Application for a non-material amendment following a grant of planning permission. Town and Country Planning Act 1990

Description of Development: Erection of single storey extension.

BR/116/20/HH

Proposed Ground Floor Plan

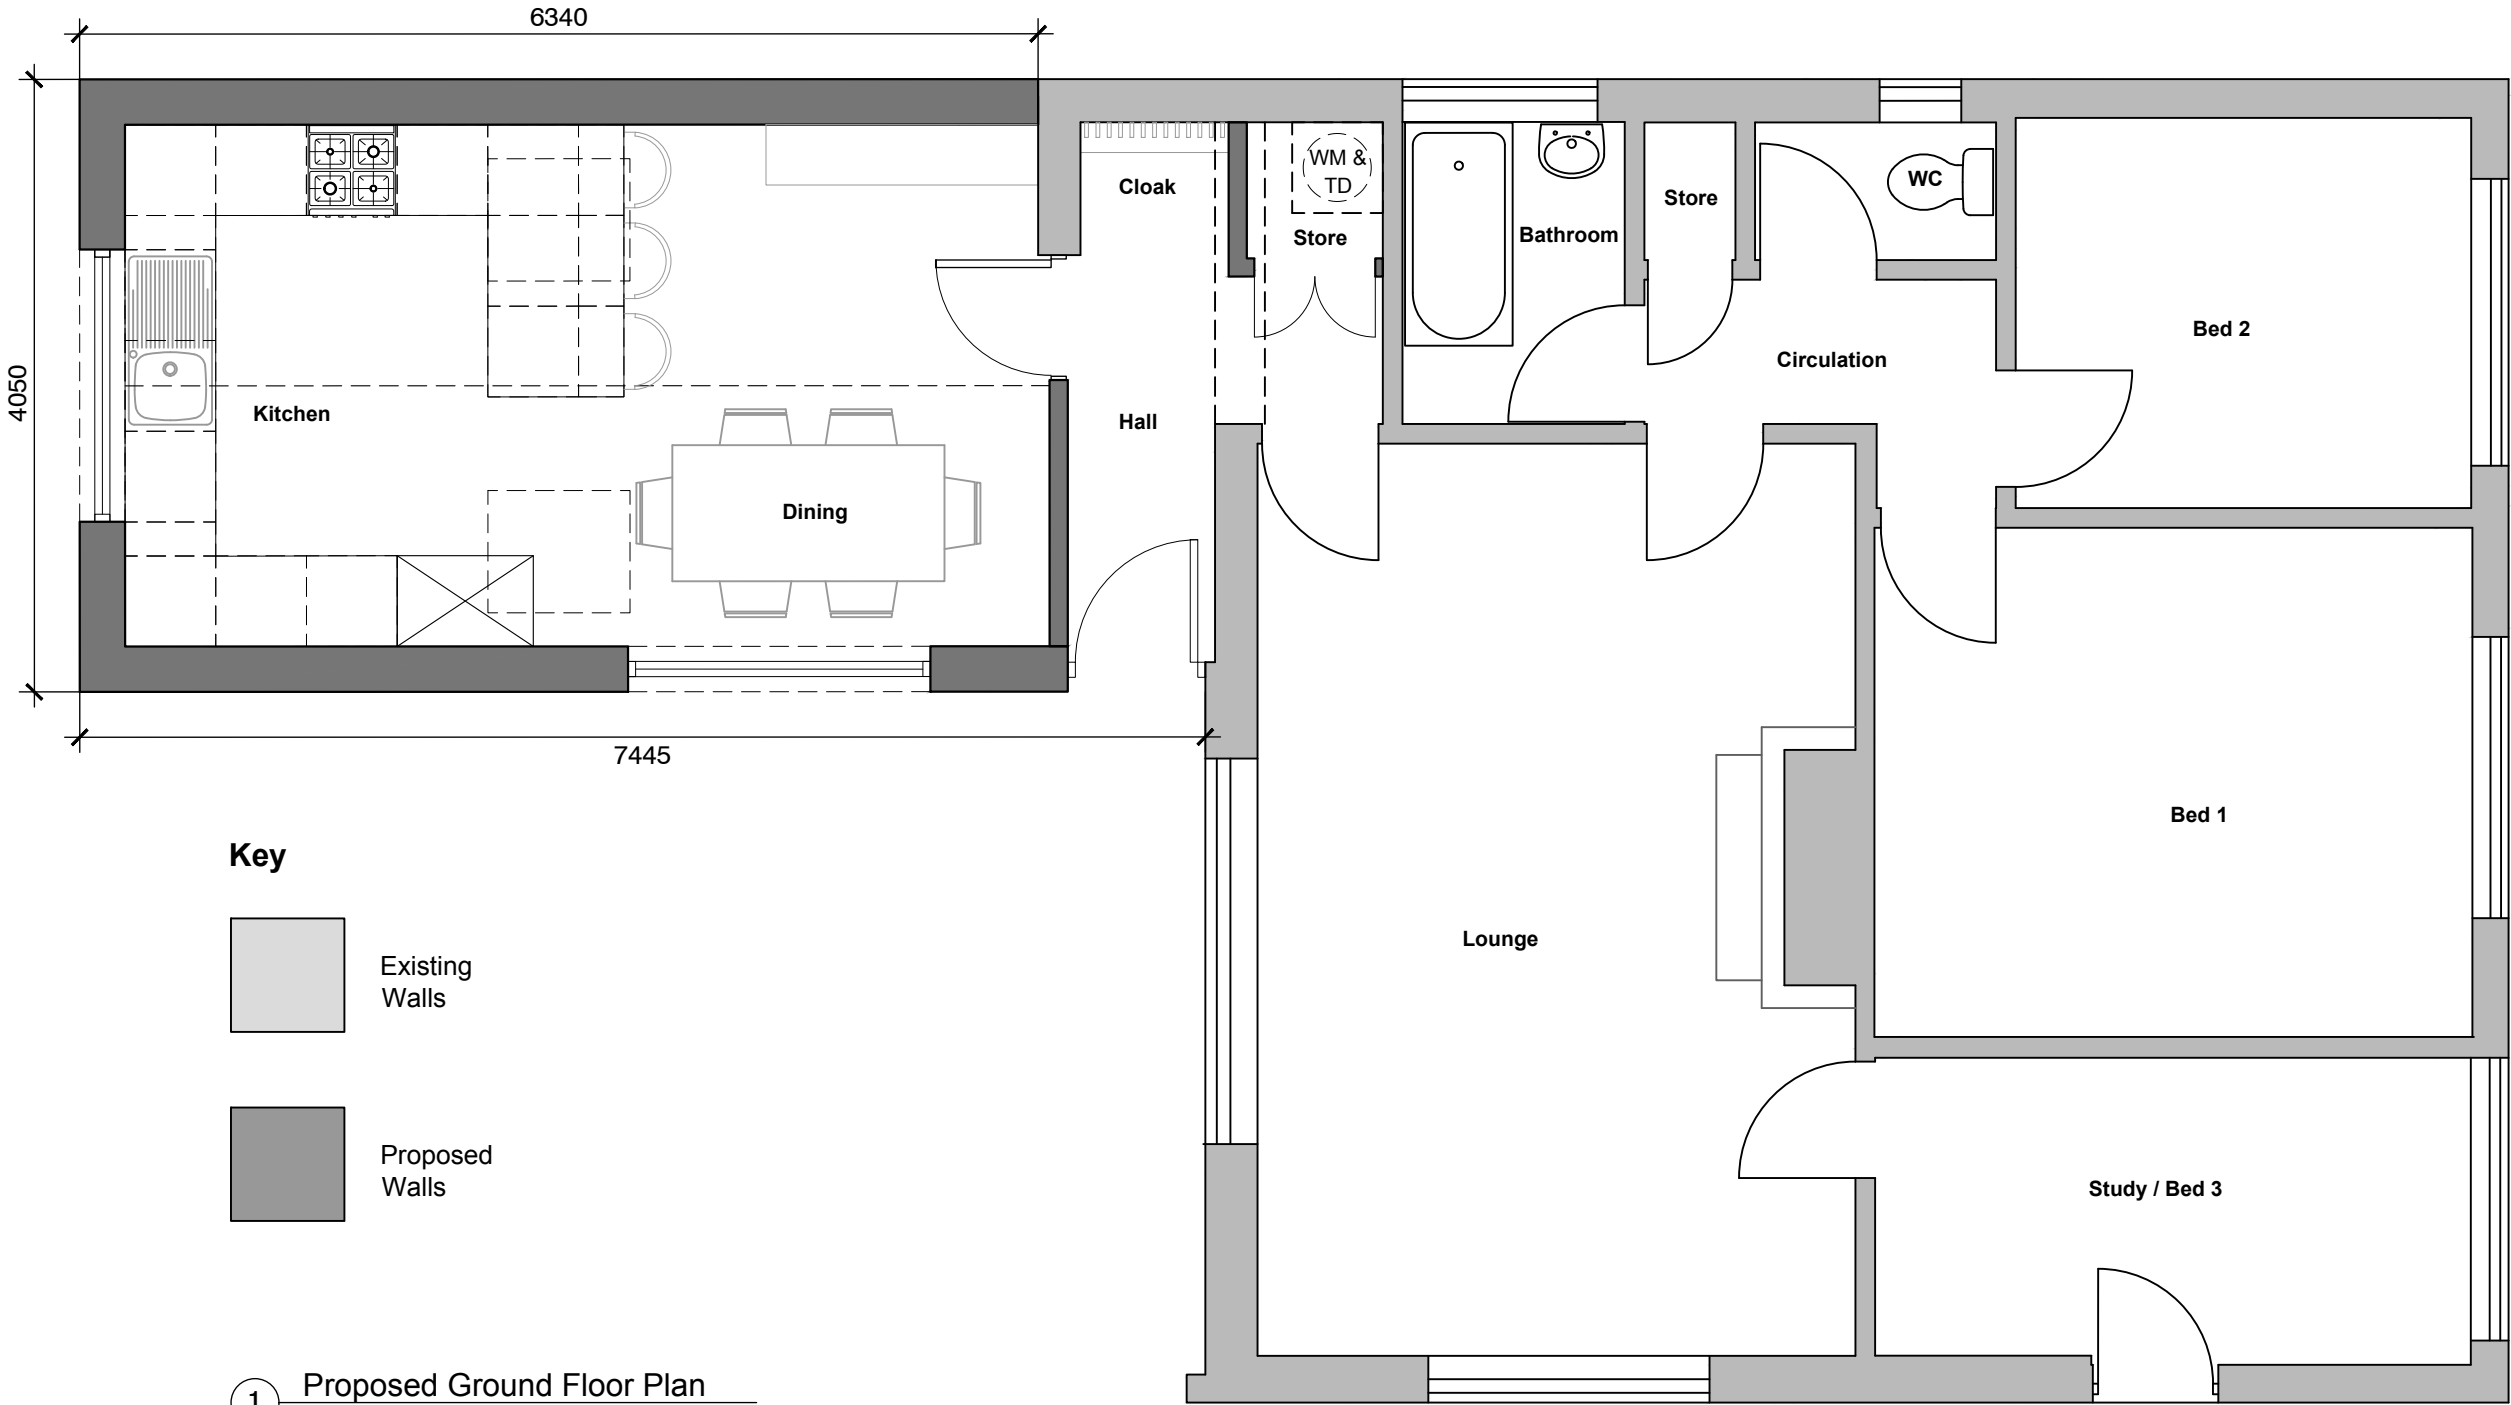
- Change the window position and reduce the number of windows on the proposed side elevation.
- Change the window on the front elevation from three frames to two frames.
